Your Ref: OWPC20804
Our Ref: R/243/18/HH 12-10-2018
Please ask for:
Zac Denton

Single storey side extension
9 Holmes Lane Rustington

Planning Application R/243/18/HH 9 Holmes Lane, Rustington. BN162QA

Drawing no 11401-ID

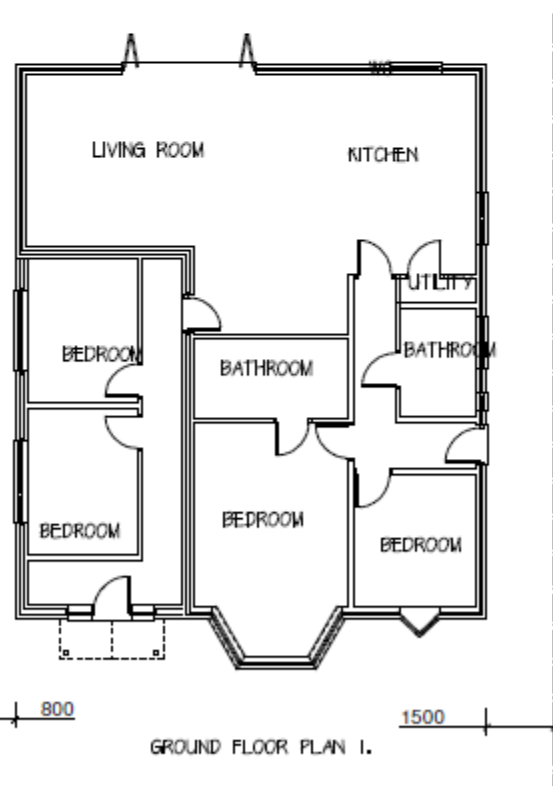
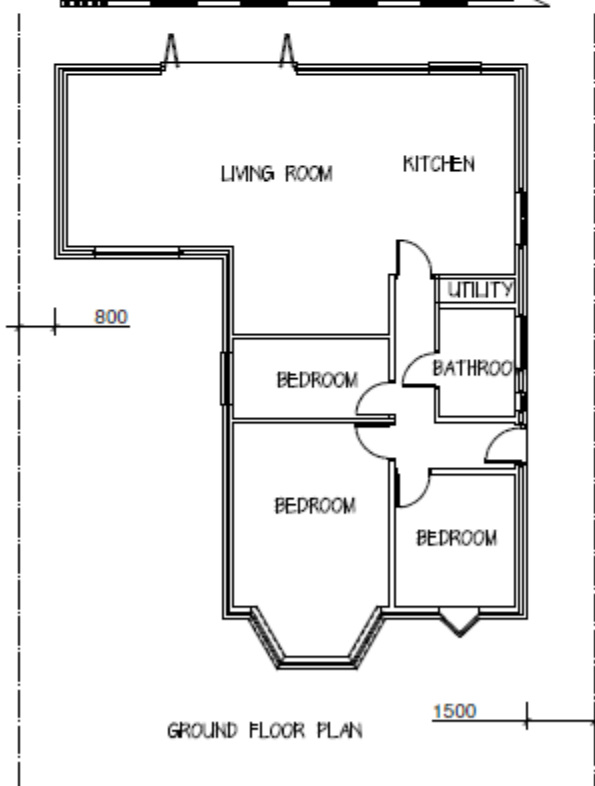
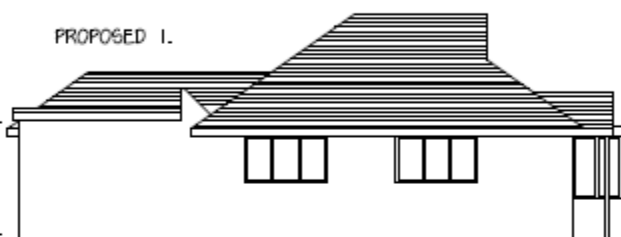
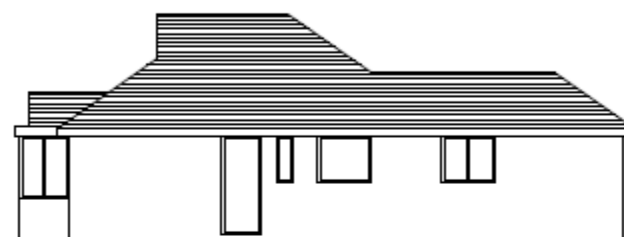
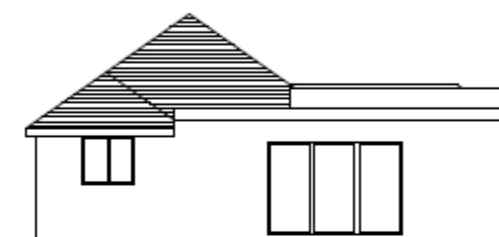
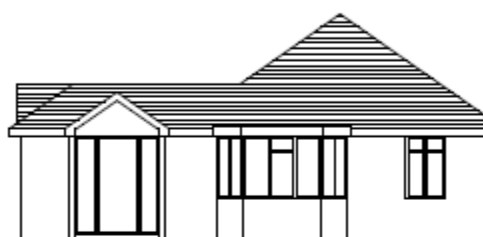
There is no precedent of, or for, a four bedroom bungalow on the street or the immediate locale. The existing bungalows of the street were originally built predominantly as two bedroom, or as a maximum, three bedroom in some dwellings. There may well have been improvements over the years, but those improvements have never affected the "Street Scene", being improved to the rear of properties where made, leaving the character and originality of the street intact and unaltered. These proposed works, being to the front and side (road facing) is seemingly at odds, out of character and incongruous with existing bungalows in the area and would alter the street scene markedly in our opinion. It would be visually detrimental as opposed to an enhancement of the area.

The scale of these proposed works, in addition to the already substantial extension completed two years ago (to the rear and side of the property) completely dwarfs and envelops the original dwelling. I would estimate a footprint double the size of the original dwelling. Again, no precedence for this, and out of character generally, with other bungalows in the street. We feel it would visually look cramped within the street scene setting.

We have genuine concerns, looking at the plans and noting two separate (front) entrances, that this property has the very real potential of becoming a multiple occupancy dwelling (HMO) at some point in the future. We base these concerns not only on the proposed works, but also the fact that the property has been repeatedly offered to market in the last two years, since completion of the existing and substantial works already mentioned.

In relation to the above concern, but not solely to that concern, the proposed works give scant consideration to parking arrangements. We note in Section 8 of the planning application submitted (Re: Parking). The applicant has indicated "No" to the question as to whether the proposed works affect existing parking arrangements? The response is, I would respectfully suggest, disingenuous. The area for the proposed works regularly accommodates two vehicles. Accordingly, the forfeiture of this space to the proposed works, renders the parking capability down to a single vehicle (4.8 x 2.4m) on the curtilage. This contravenes the councils own supplementary planning guidance on parking standards for a (proposed) four bedroom dwelling by some considerable margin.
